East Park Energy construction traffic evidence submission: construction material and delivery traffic reconciliation, omitted traffic categories and wider transport issues

Submission: For the attention of the Examining Authority, National Highways, Bedford Borough Council, Cambridgeshire County Council and Huntingdonshire District Council

1. Introduction: Construction traffic reconciliation, delivery categories and wider transport issues

Status
DCO Application

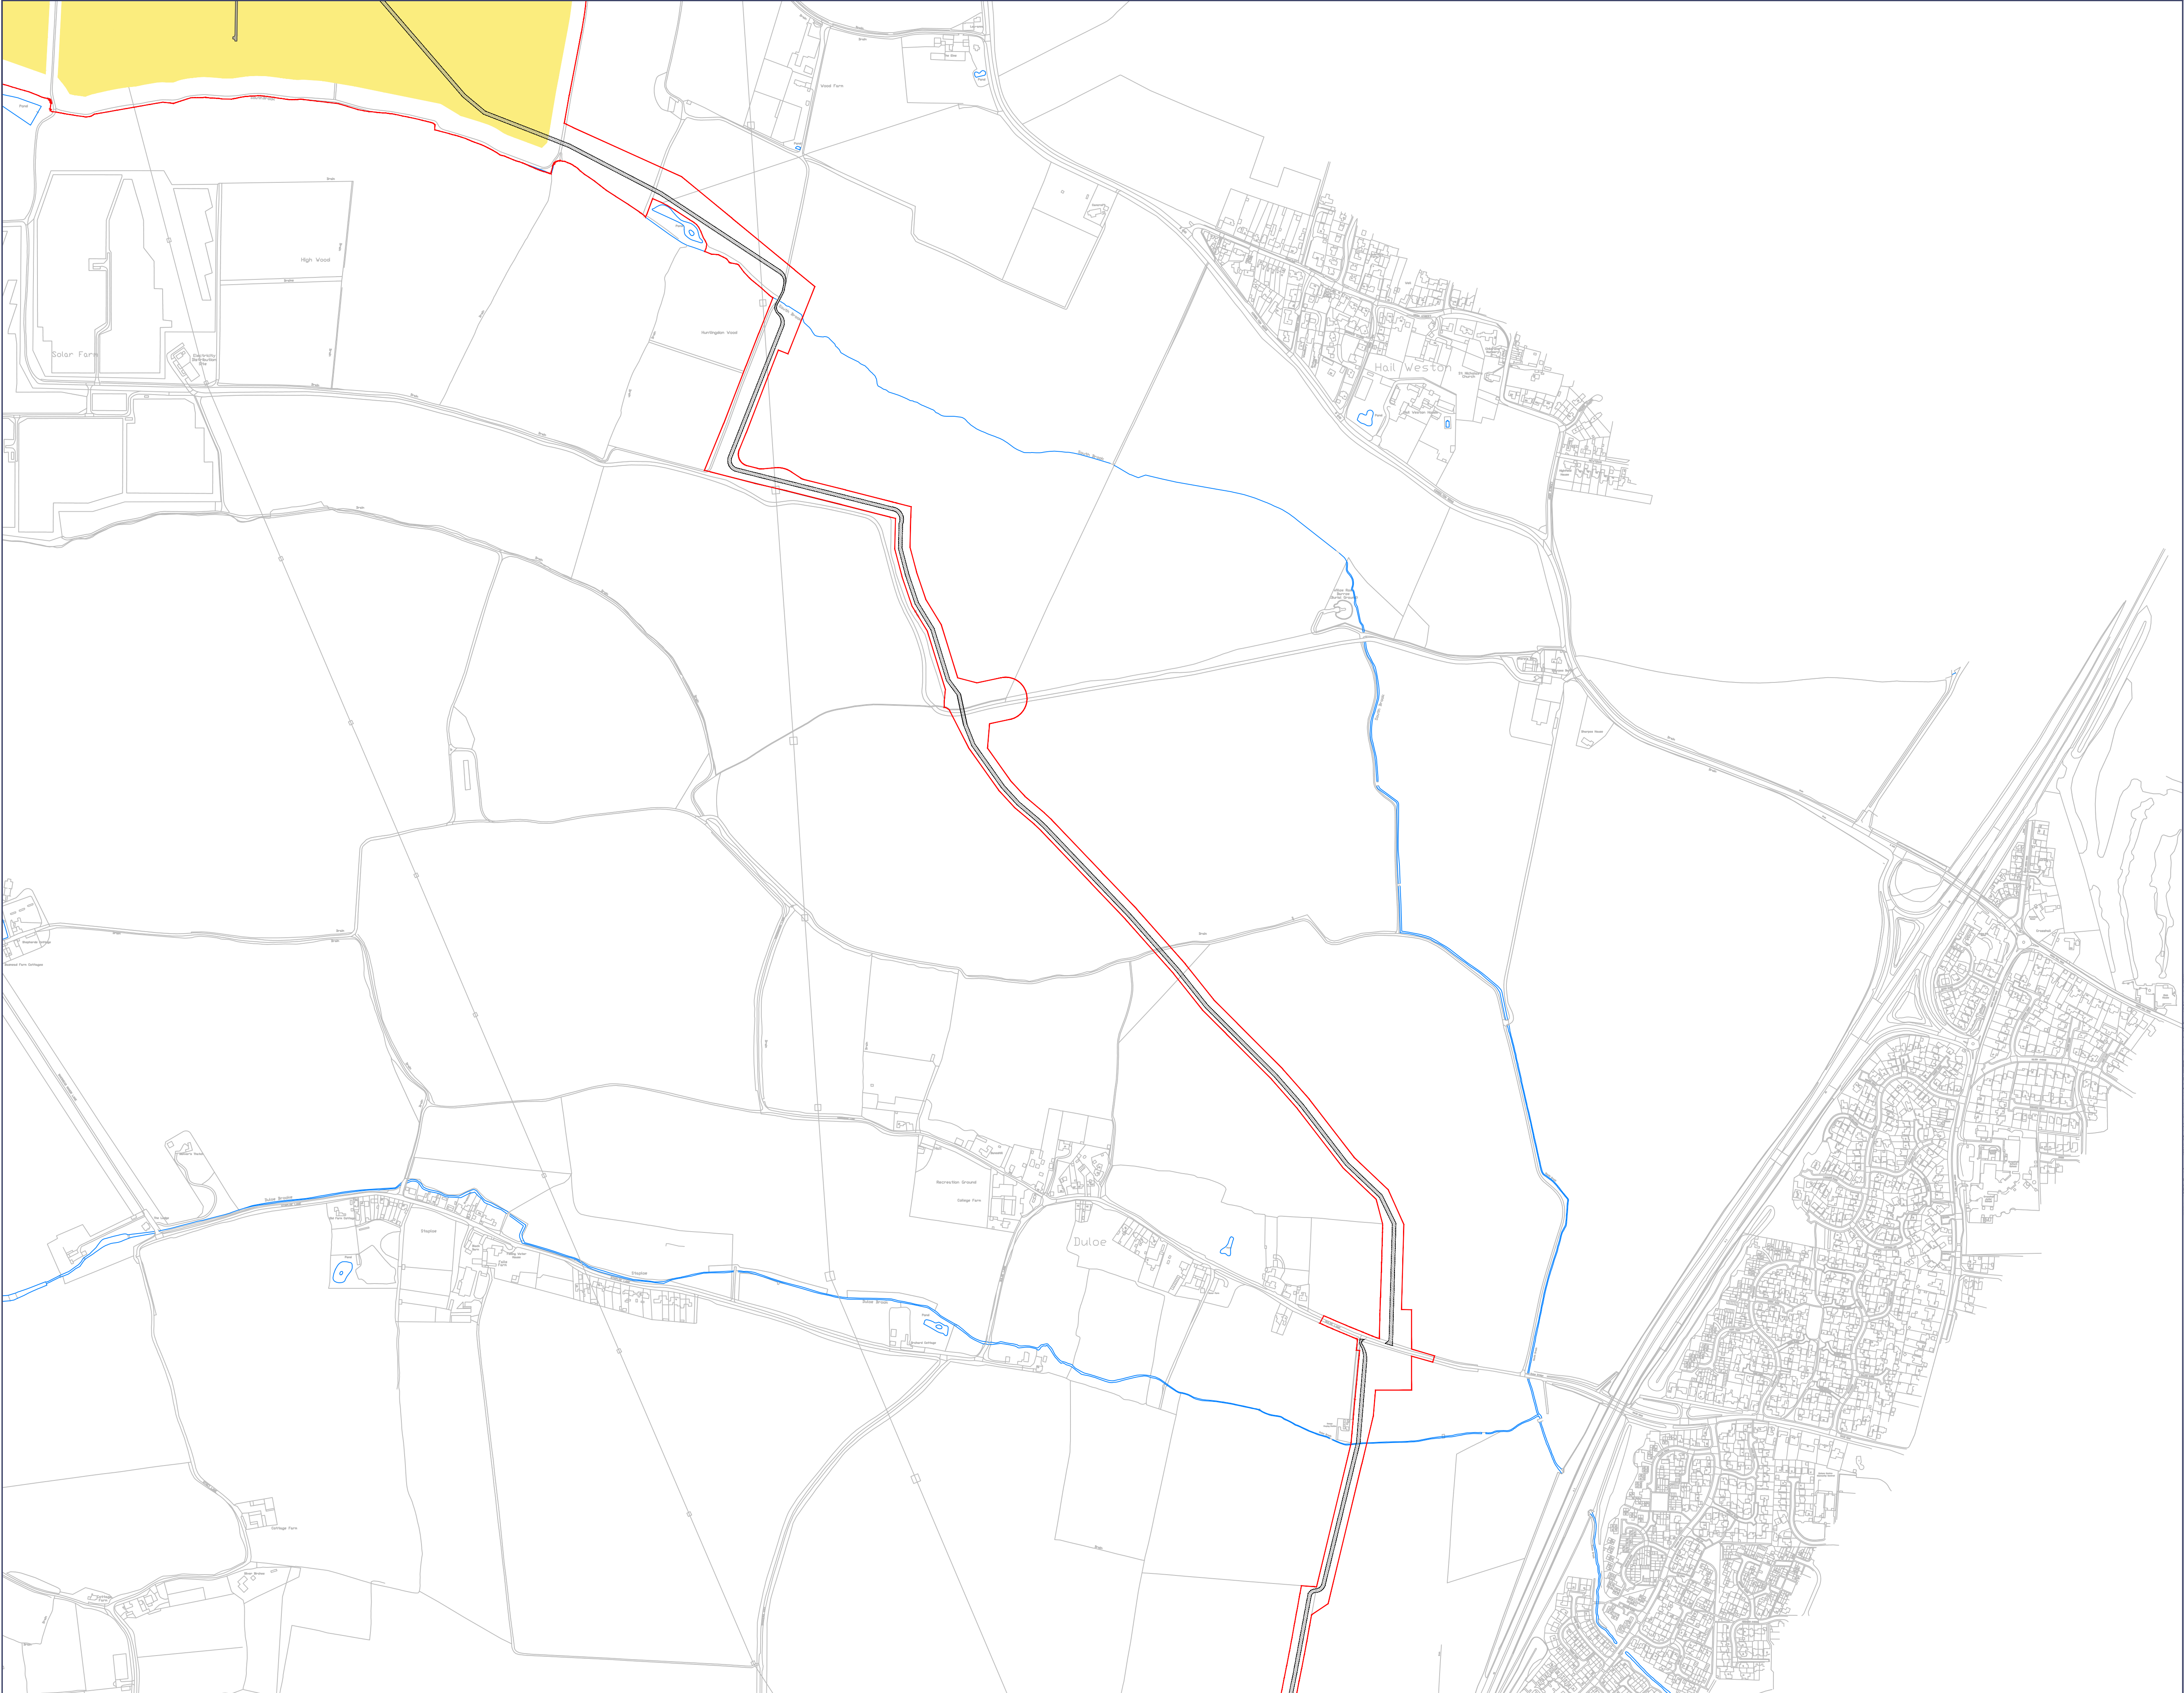
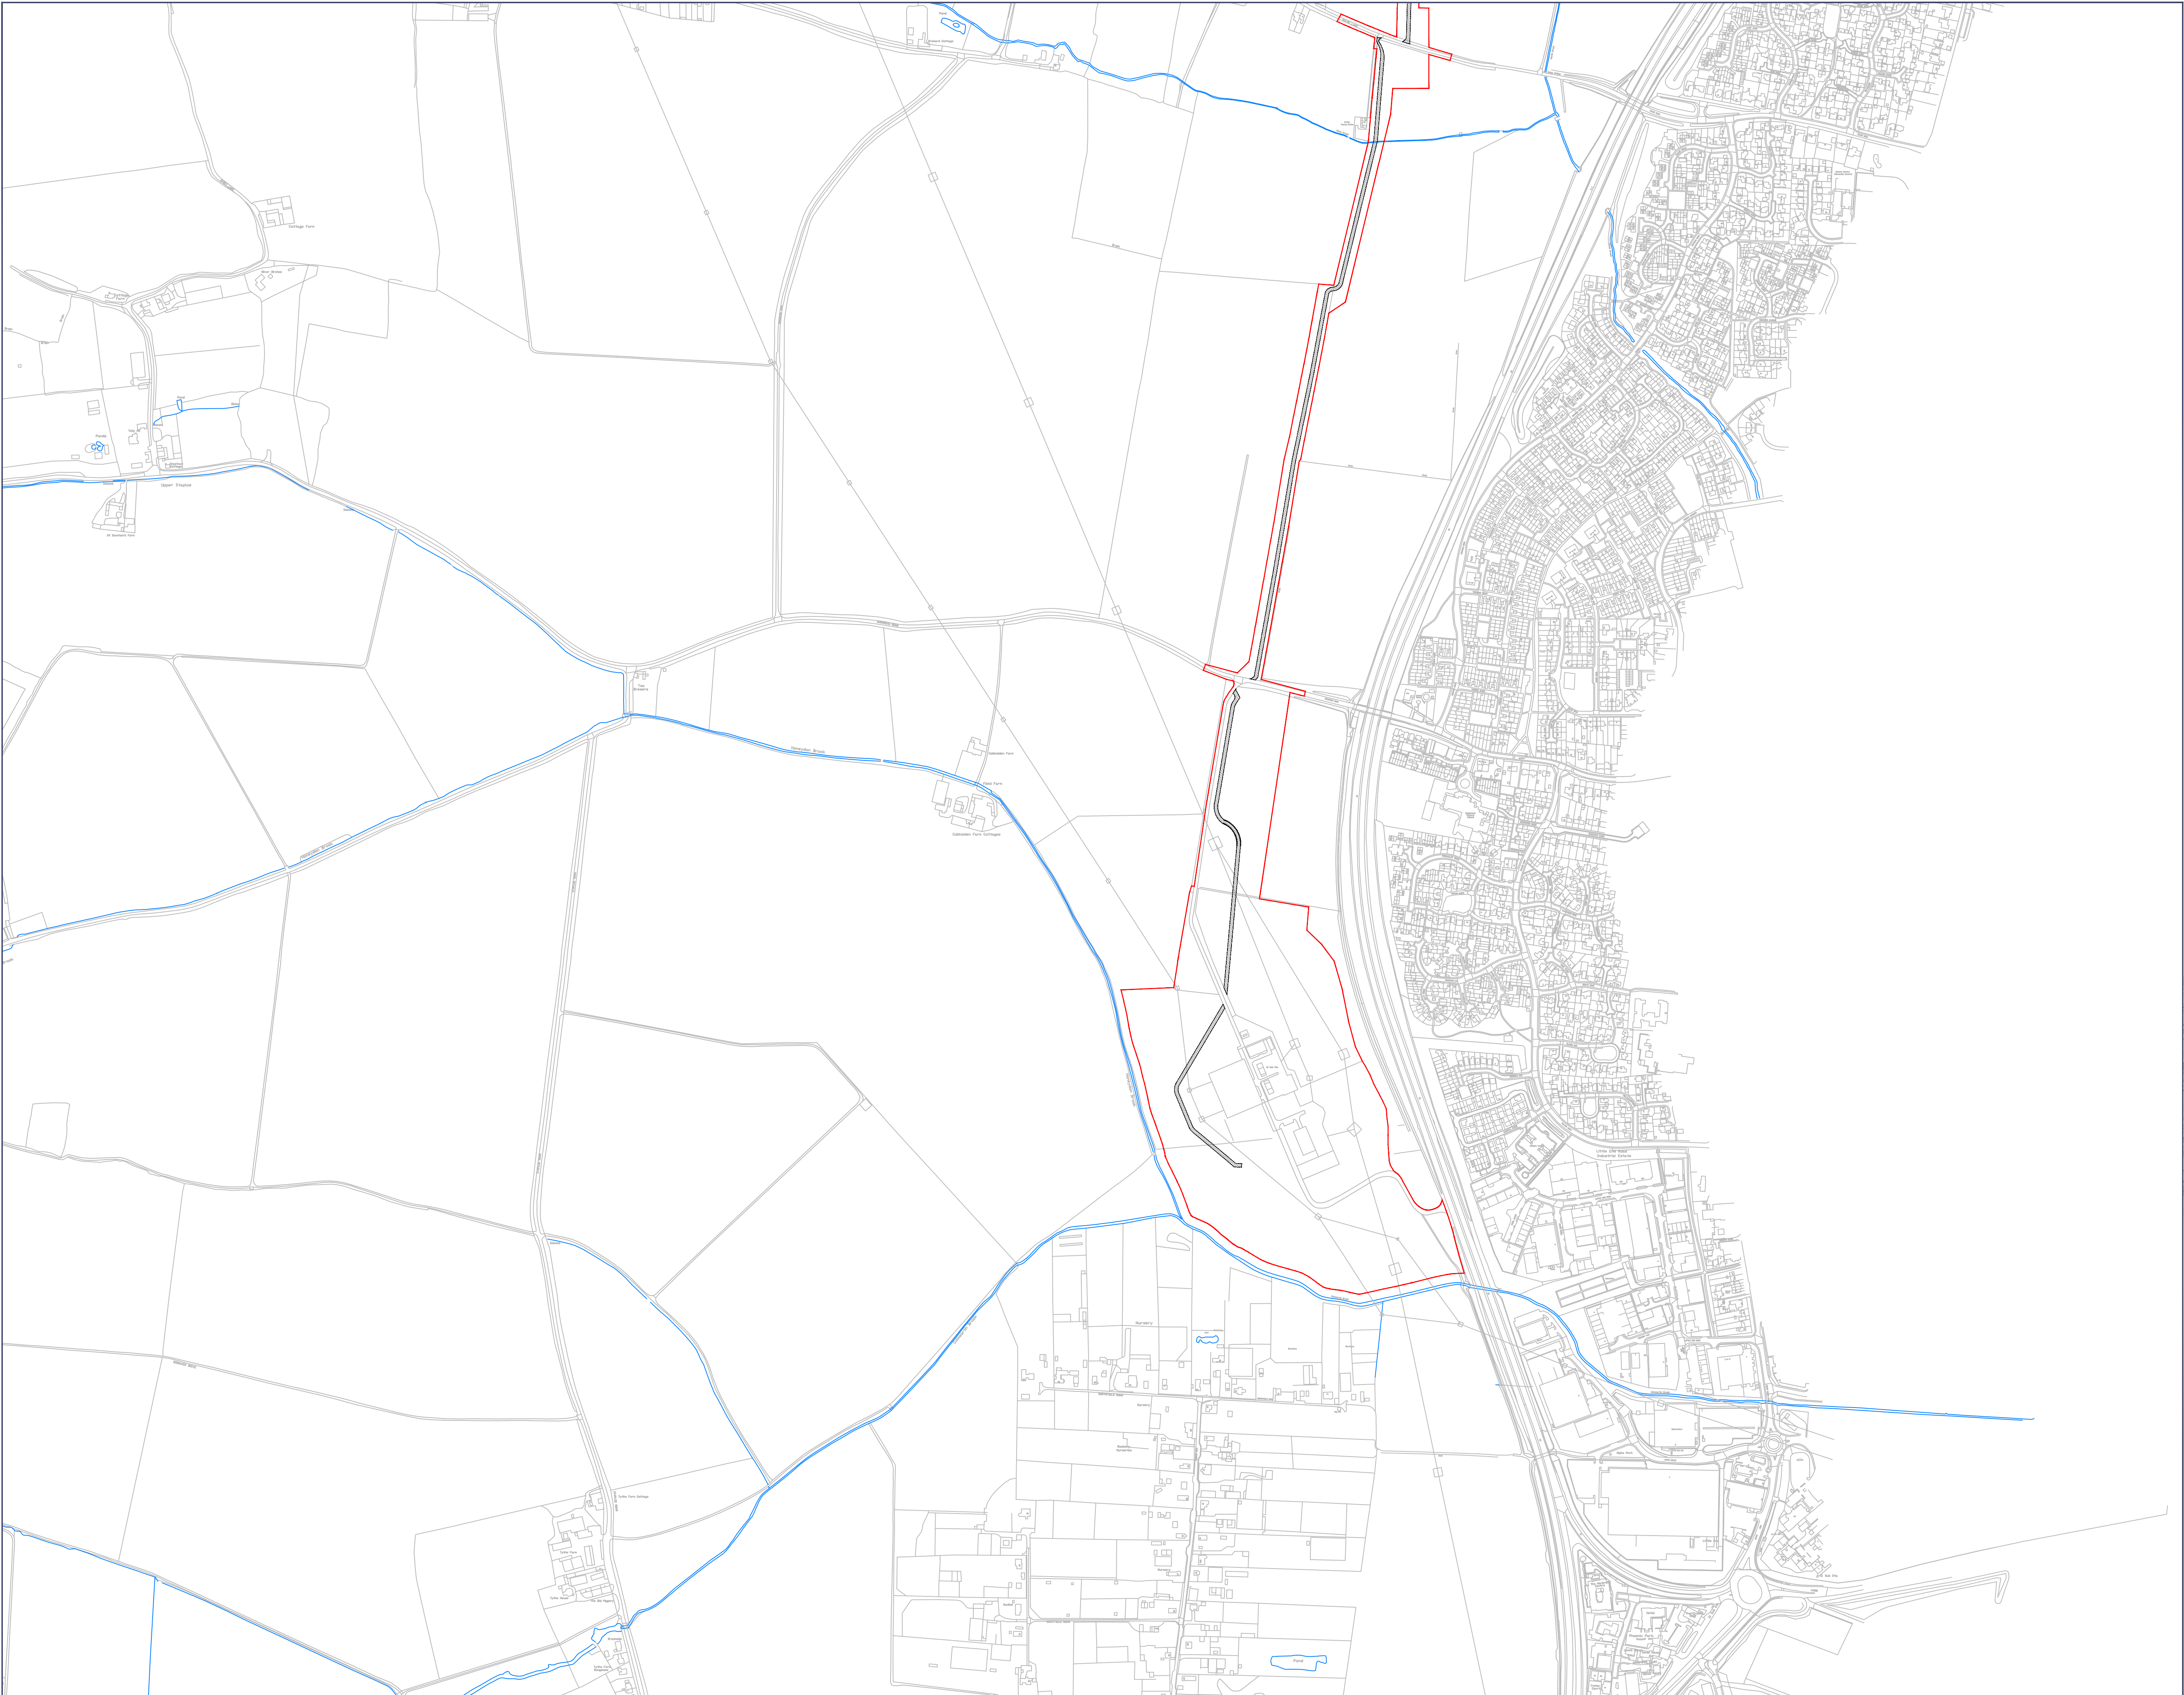
- **Pavement materials for car parks.** It is assumed that all the car parking areas at the main and 11 satellite compounds would be constructed using bituminous materials to provide a suitable surface for all vehicles and to avoid mud being deposited on the access tracks and local roads. Large areas of car parking are required to meet the requirements set out in paragraph 4.4.2 of the ‘Outline Construction Traffic Management Plan’ (REP3-050):

The HGV trips required to deliver any bituminous materials appear to have been omitted from the Applicant's construction traffic trip generation calculations. Similarly, any trips to deliver/remove all associated construction plant to lay and compact the road pavement layers of the car parks also appear to have been omitted.

- **Vehicles and plant movements associated with removal of some sections of the internal haul roads post-construction.** Under plans set out in Figure 15 'Proposed Construction Access Strategy' in Appendix C of the 'Outline Construction Traffic Management Plan' (REP3-050), SEPE calculates that up to 8.2km of tracks may be removed between:
 - Sites B and C,
 - Sites C and D, and
 - Site D and the Eaton Socon substation.

Accordingly, SEPE suggests that additional HGV trips would result on sections of Great Staughton Road, Spring Hill, B645 to the east of Great Staughton village and Moor Road during the replacement works and the decommissioning phase due to the removal of these sections of the internal haul road post-construction.

SEPE notes that more HGV trips would be generated if the removed sections of the internal haul roads were reconstructed for the replacement works and the decommissioning phase.
